**CITY OF ALBUQUERQUE
PLANNING DEPARTMENT
July 15, 2015
DRB Comments**

PROJECT # 1002134 APPLICATION # 15-70234/ 70243

RE: Lot 6, Las Lomas Business Park

**CITY OF ALBUQUERQUE
PLANNING DEPARTMENT
April 29, 2015
DRB Comments**

PONTILUX
1301 CUESTA ABAJO CT. NE
Albuquerque, NM
Bernalillo County

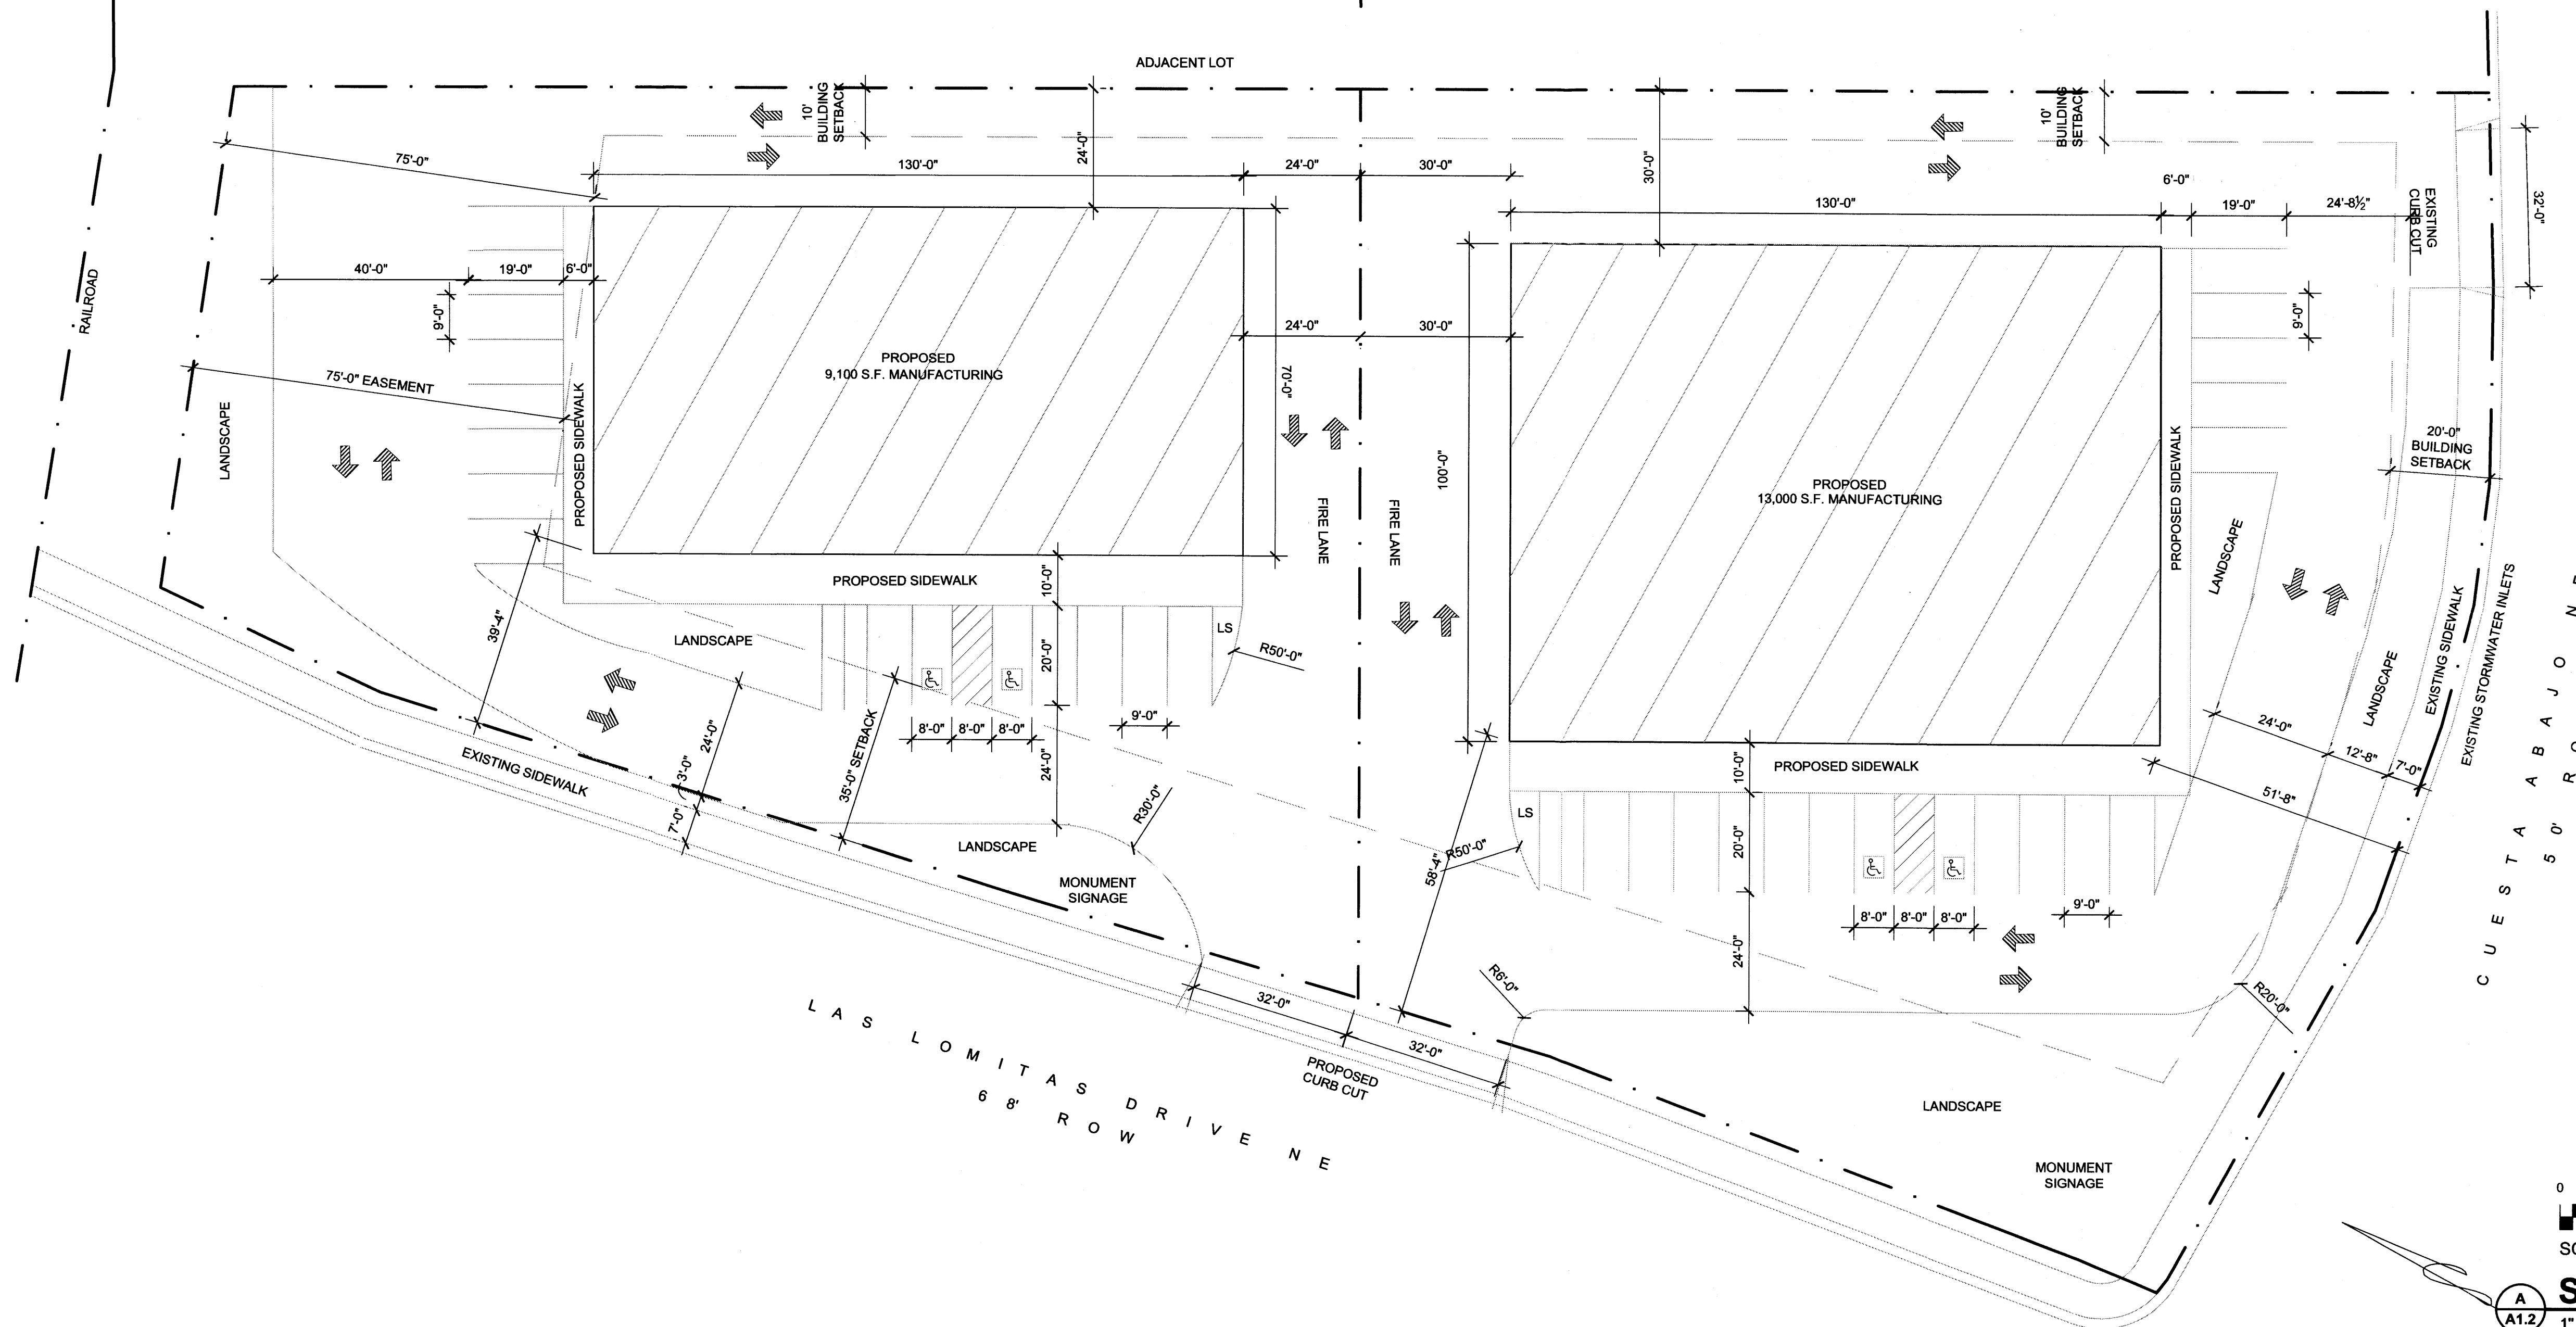
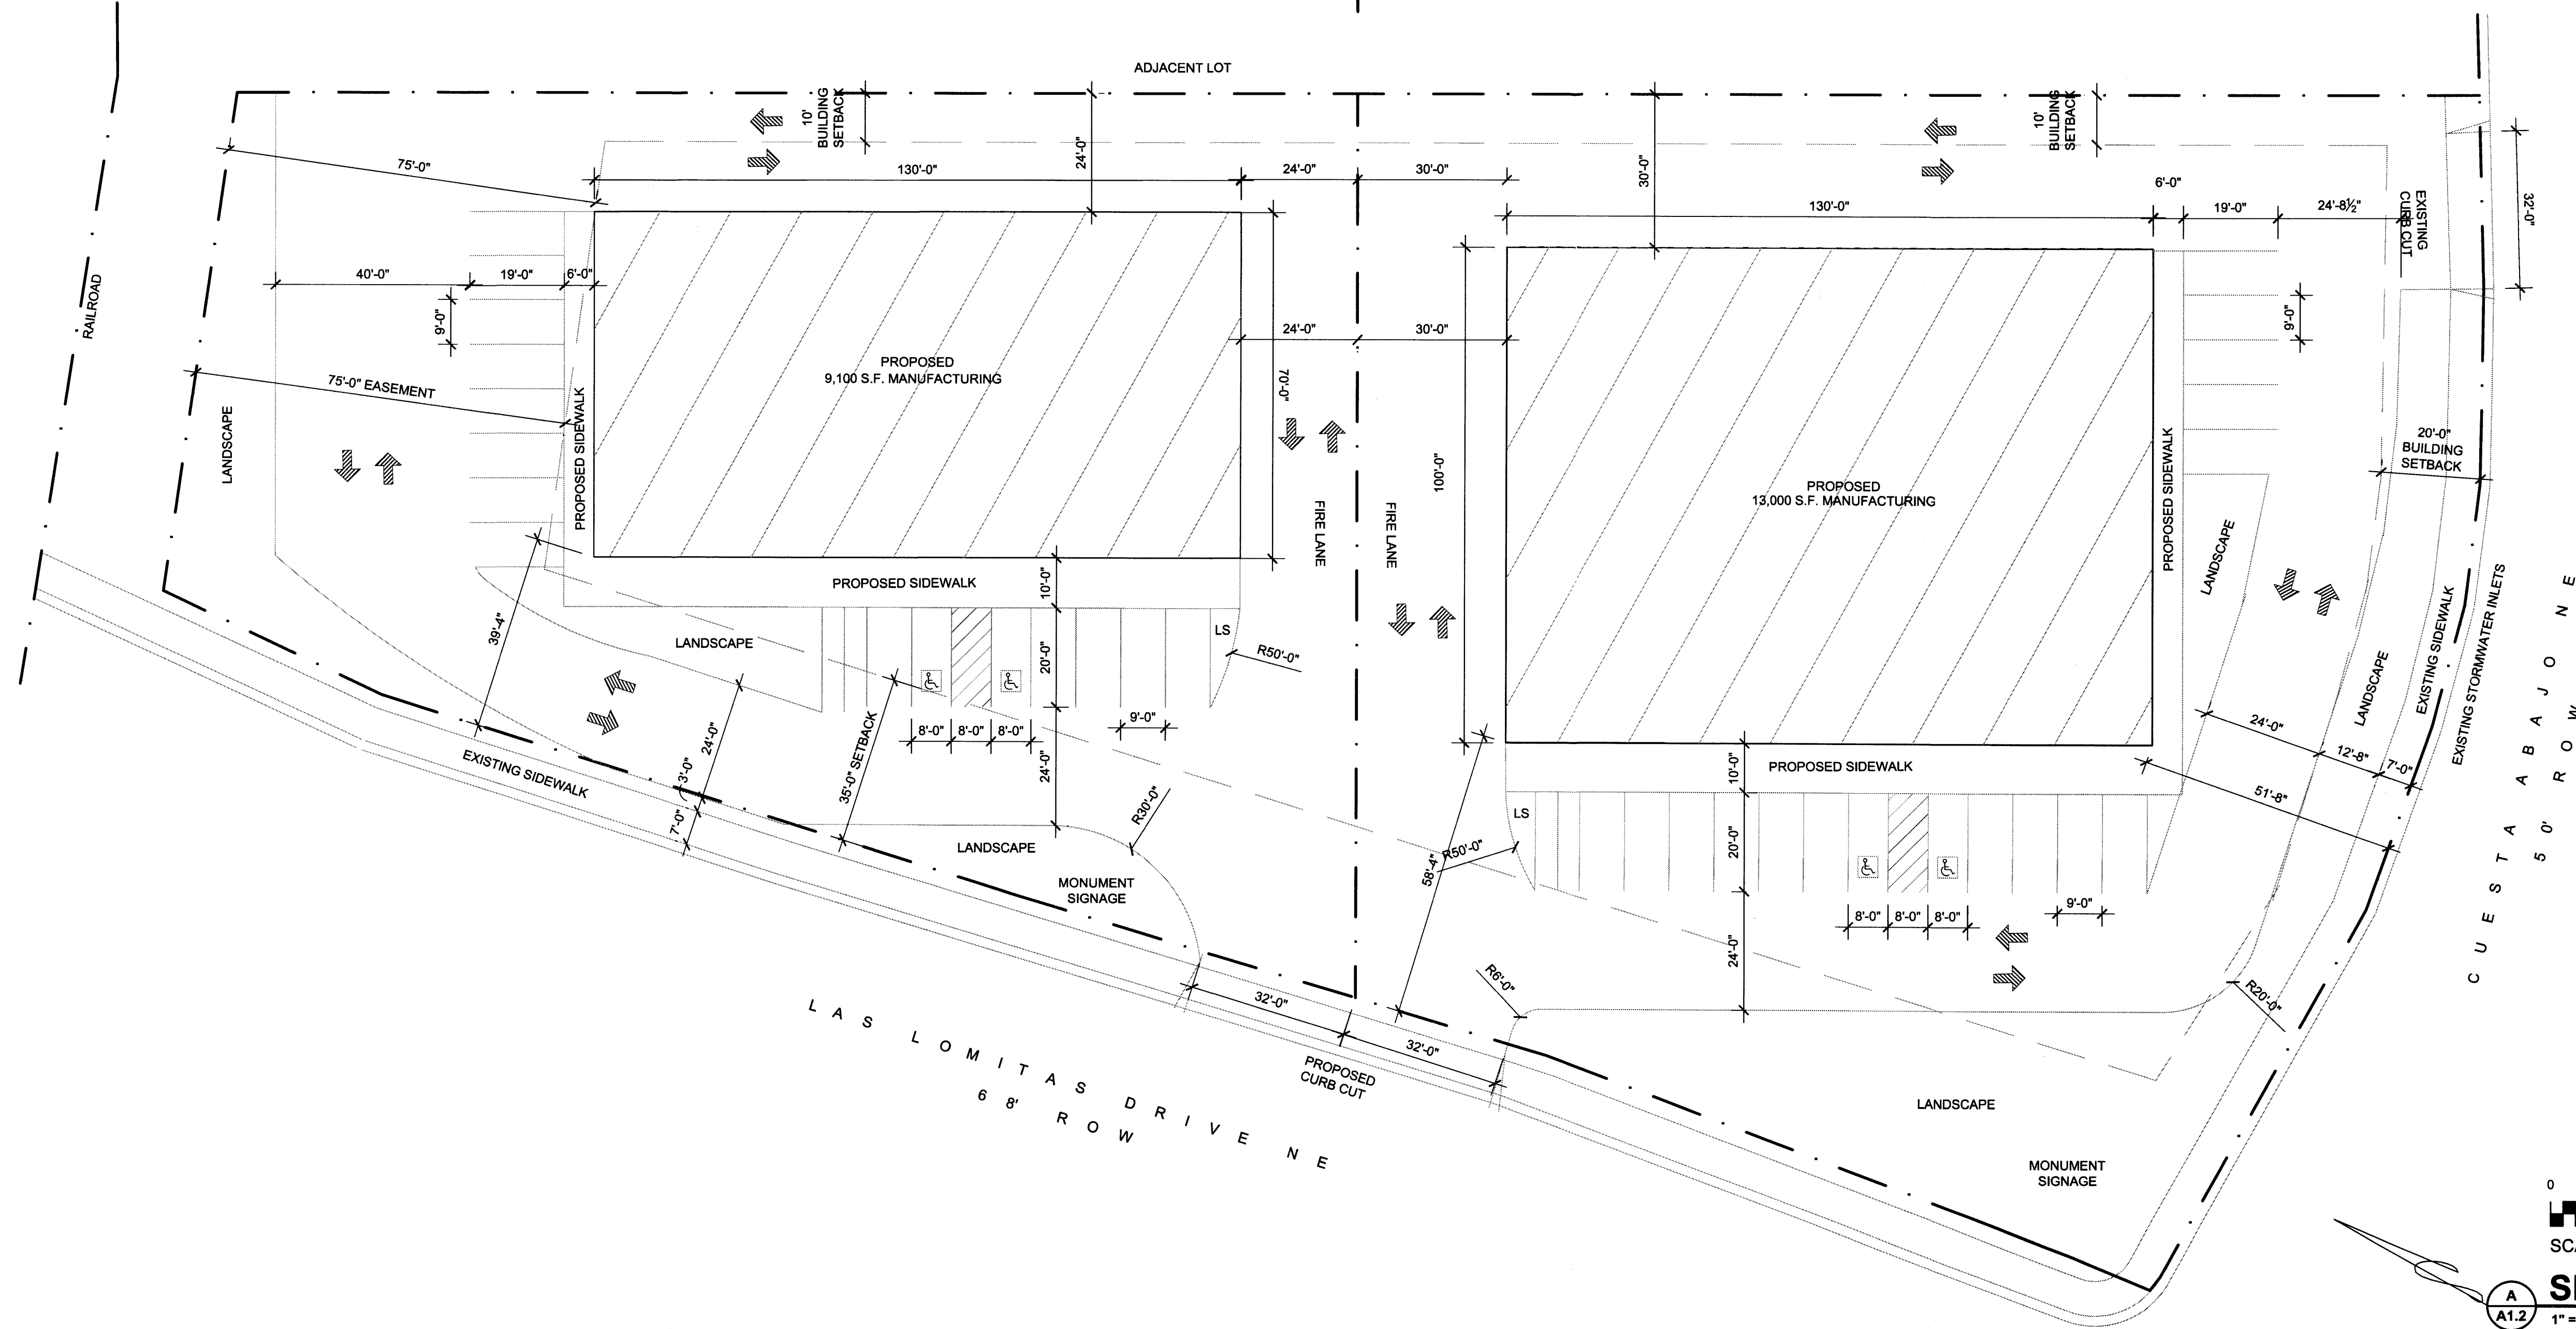
For Site Plan for Building Permit, Motorcycle Parking is a separate calculation from Vehicular Parking (same as Bicycle Parking).

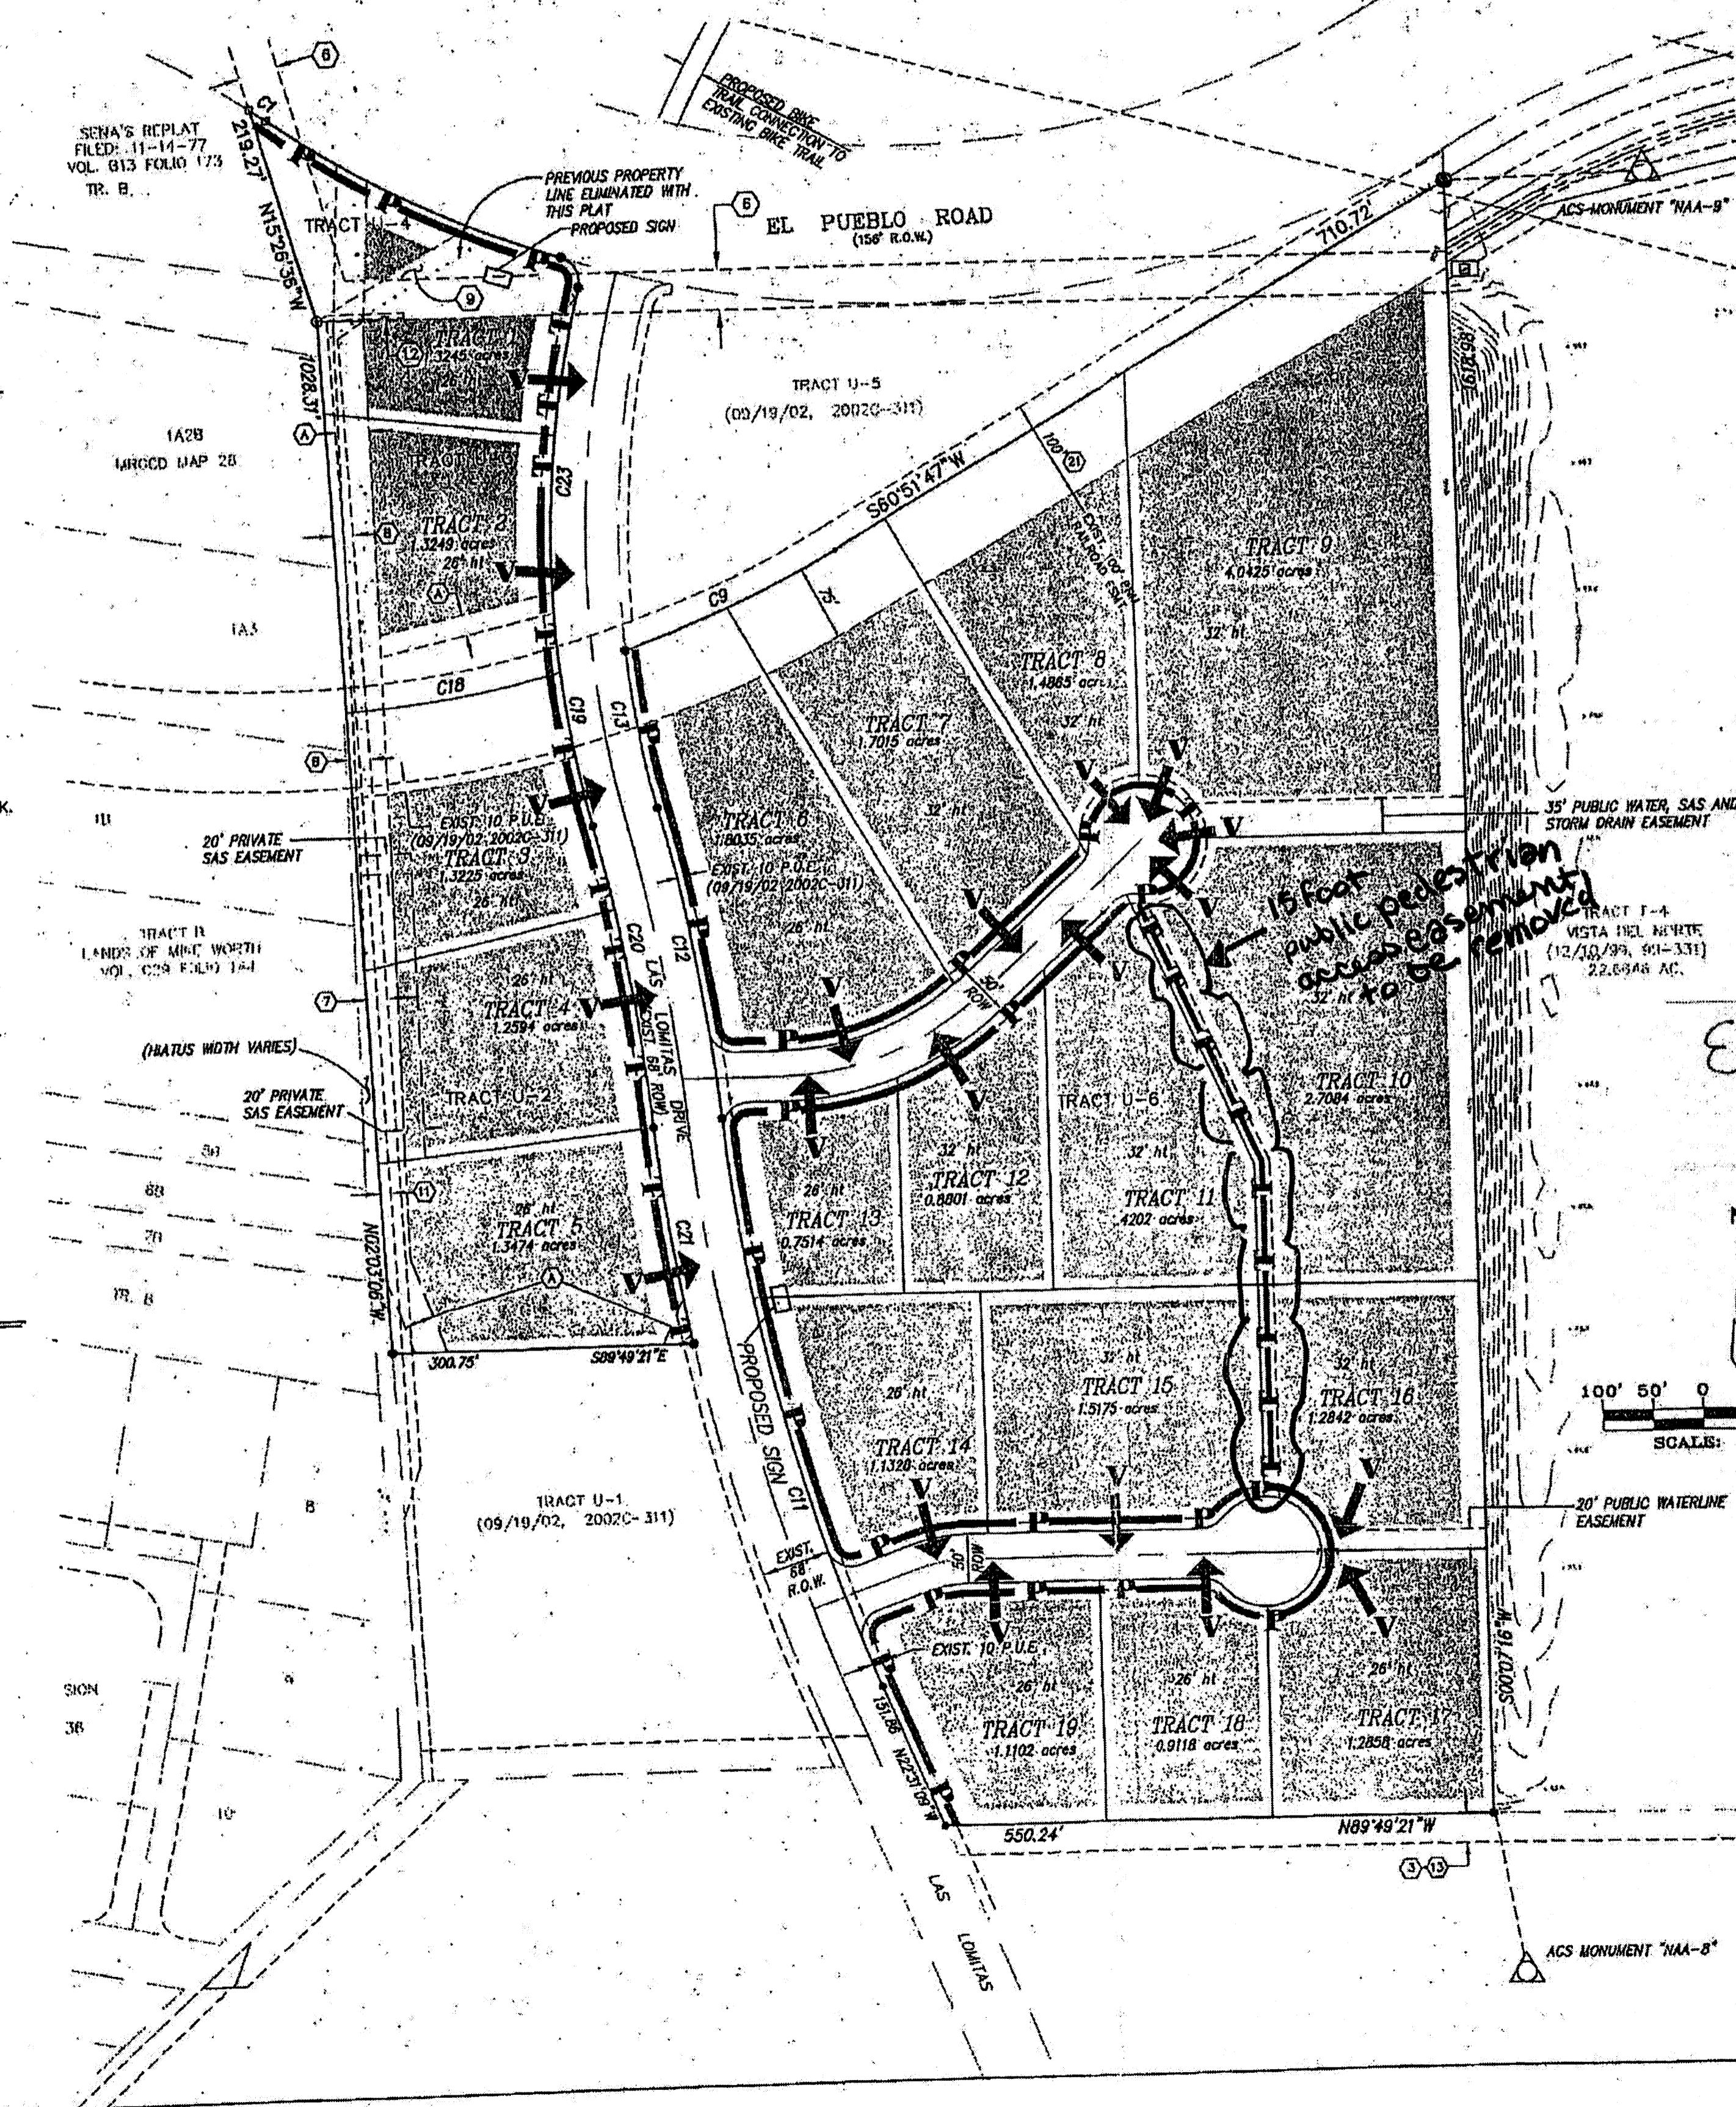
The Amended Site Development Plan for Subdivision must be an amendment of the latest site plan to show new lot line – see attached.
